CITY OF ALBUQUERQUE

Re: 1128 Stanford Dr NE, As-Built Drainage Plan
Engineer's Stamp date 7-2-10 (J16/D022)

LOT 20, BLOCK 4, SUNSET TERRACE ADDITION ASBUILT DRAINAGE PLAN			
DRAWING:	DRAWN BY:	DATE:	SHEET #
2010-RNLD5.dwg	SBB	07-02-2010	1 OF 1

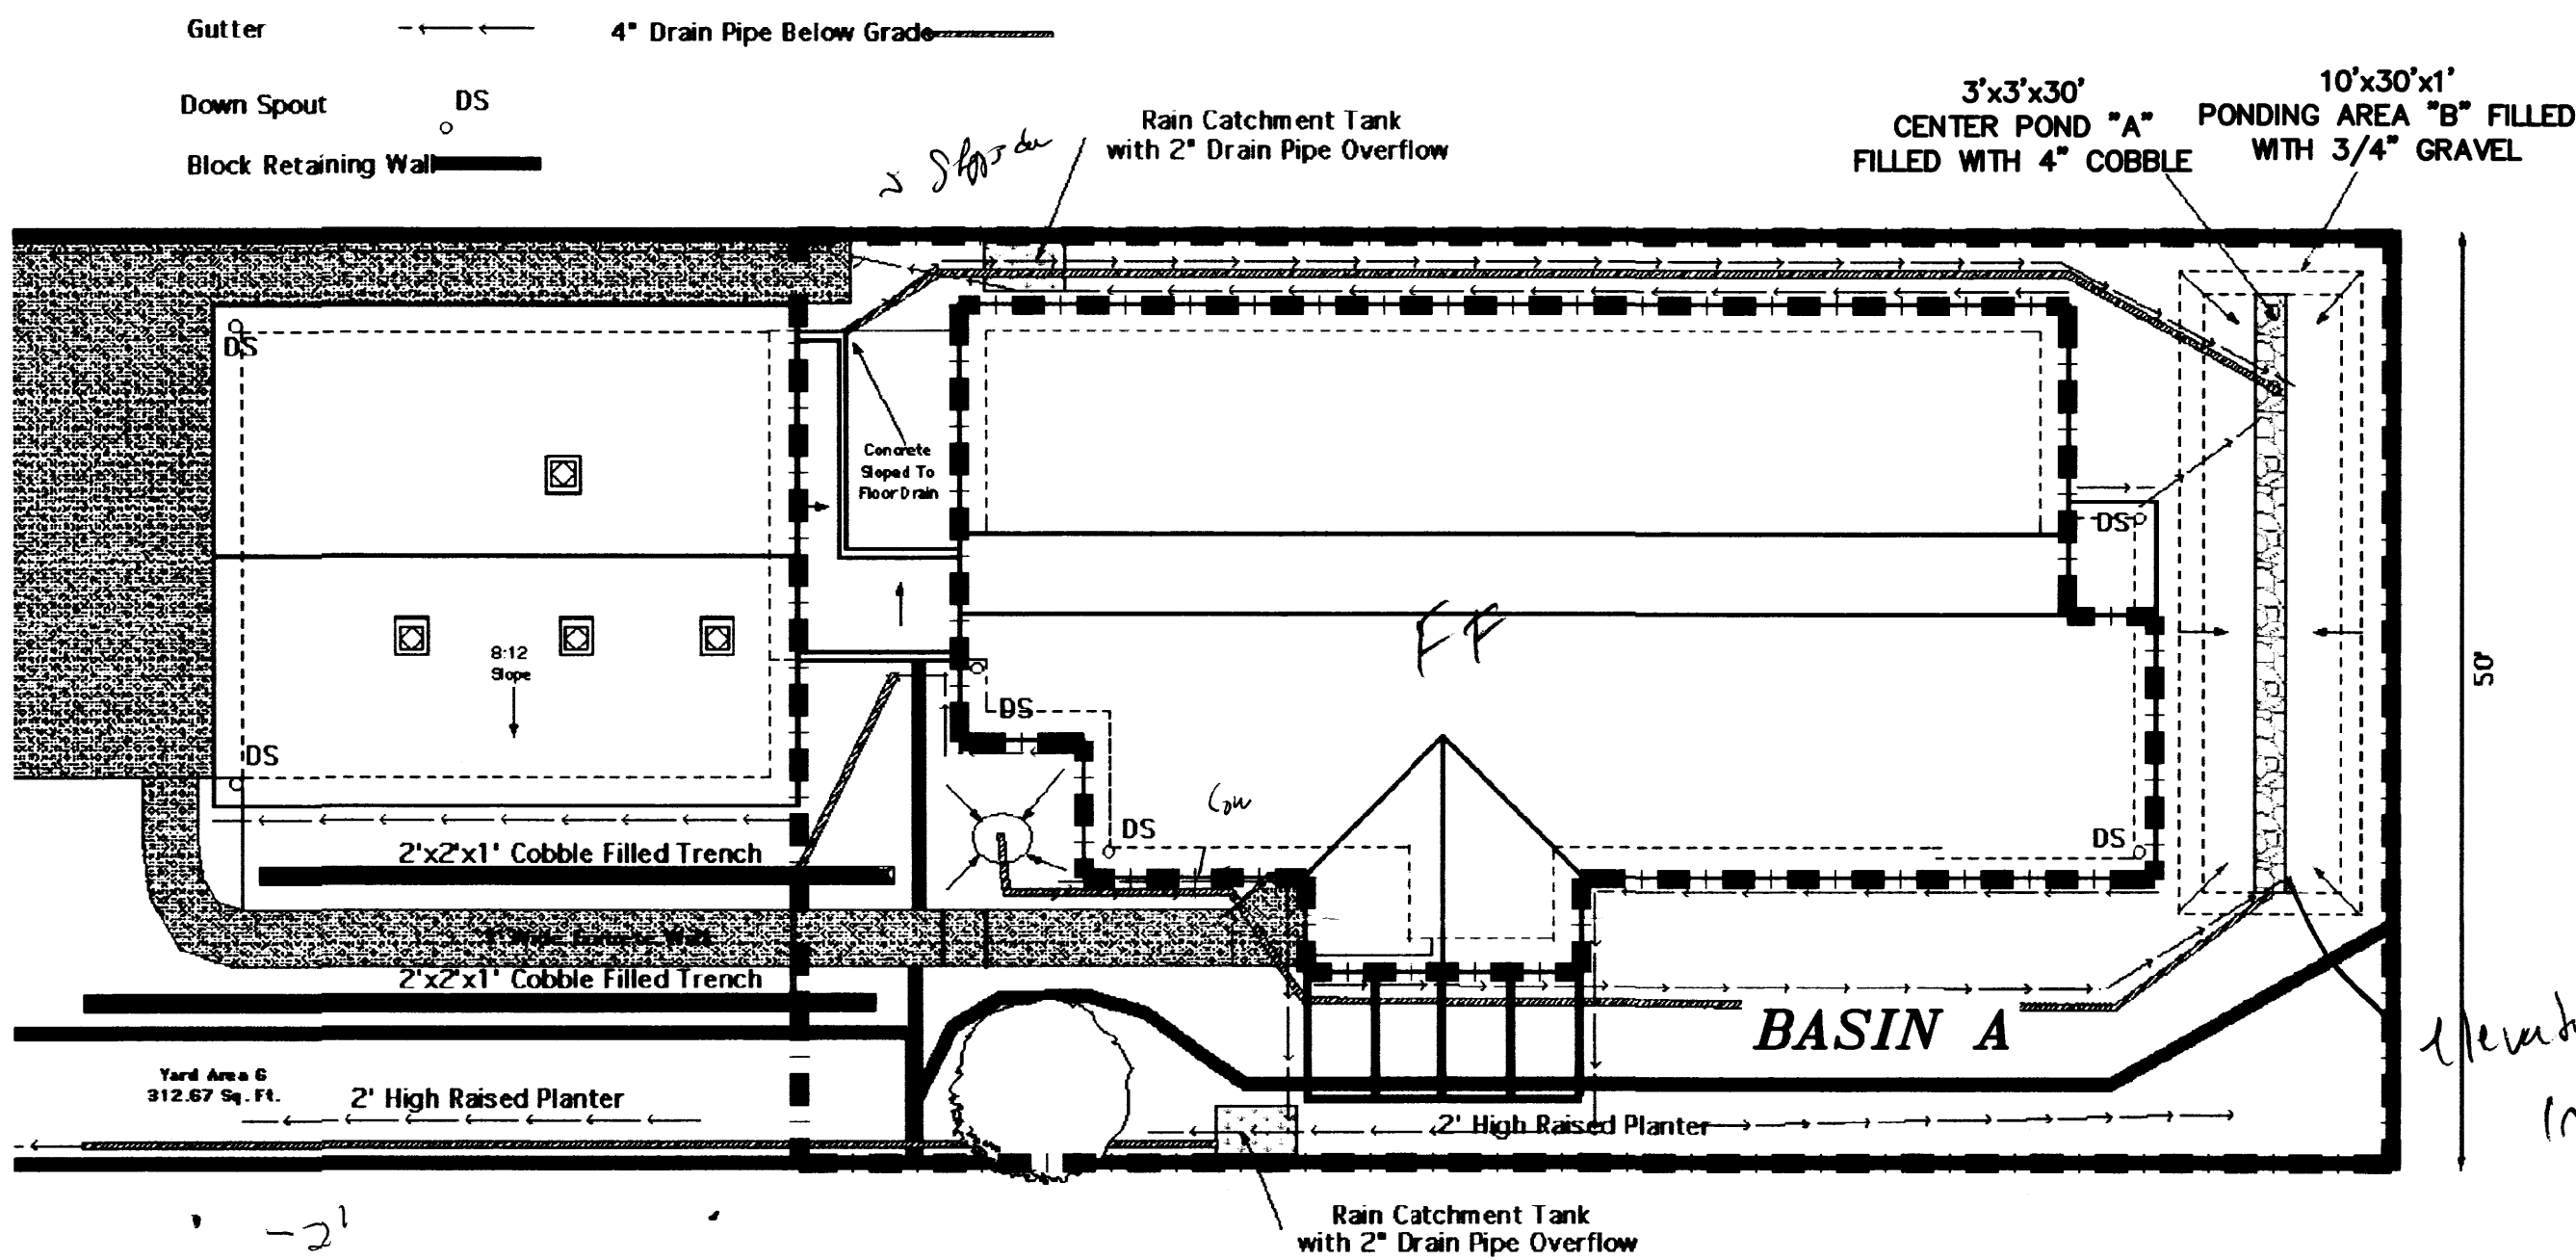
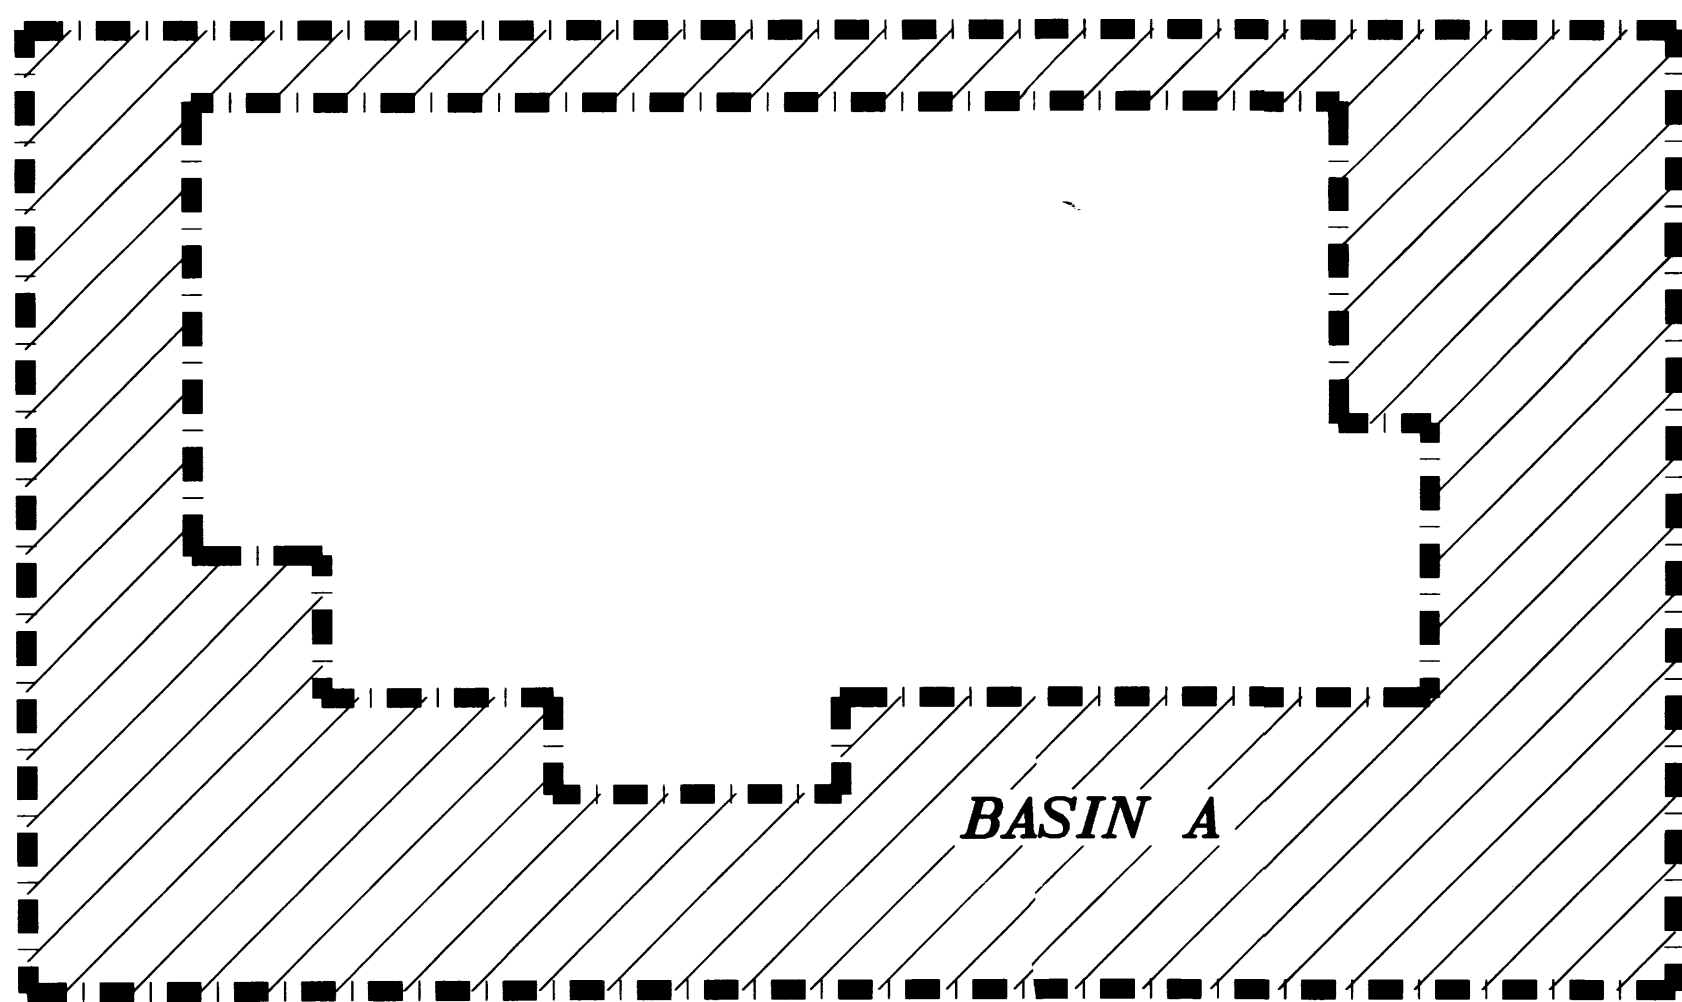
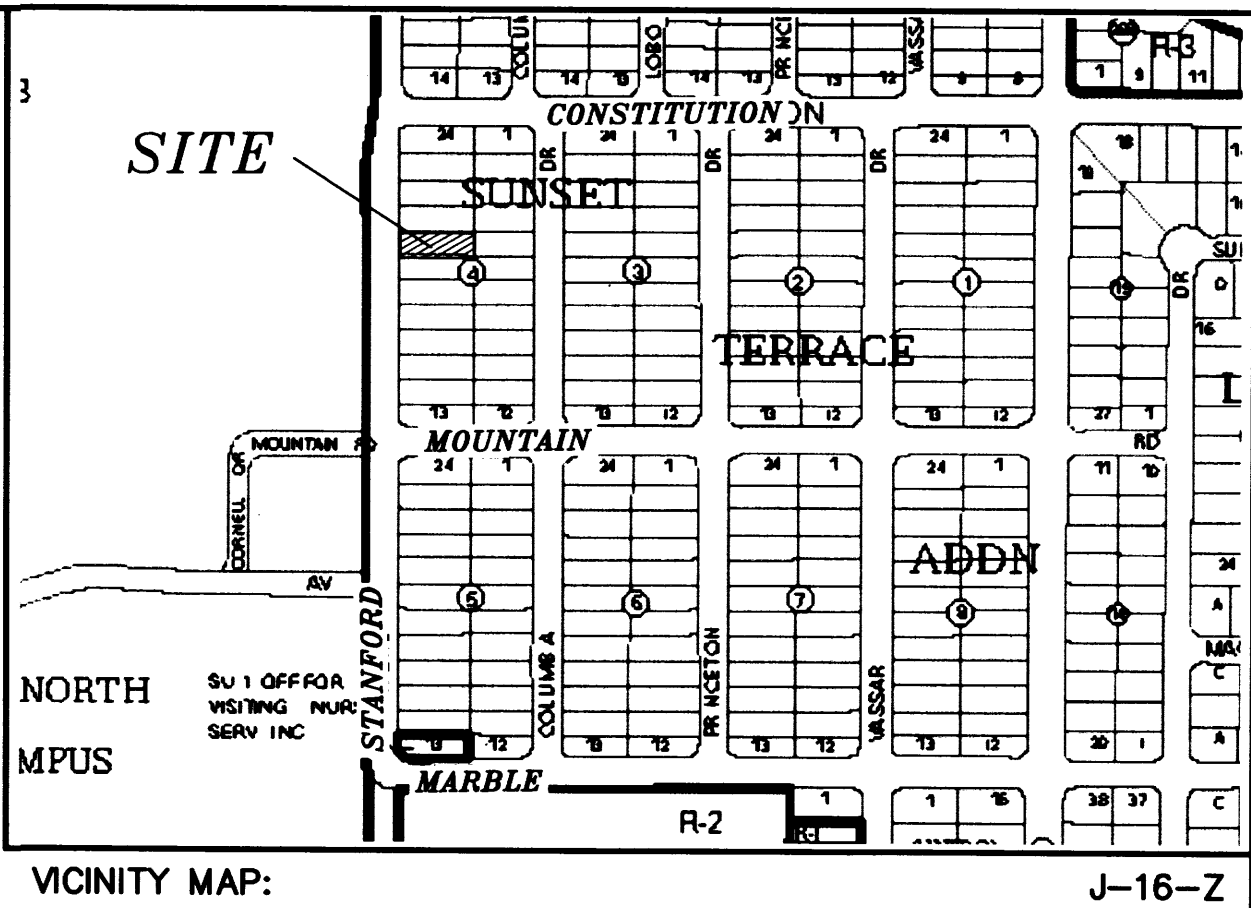
Based upon the information provided in your submittal received 7-6-10, the above referenced plan cannot be approved for an as-built for the following reasons:

- A Grading Plan was not required for Building Permit approval.
- Most residential lots drain to the street.
- There are no grades on this plan.

This plan does not need to be resubmitted as an approval is not required. The property must comply with the City of Albuquerque's Drainage Ordinance.
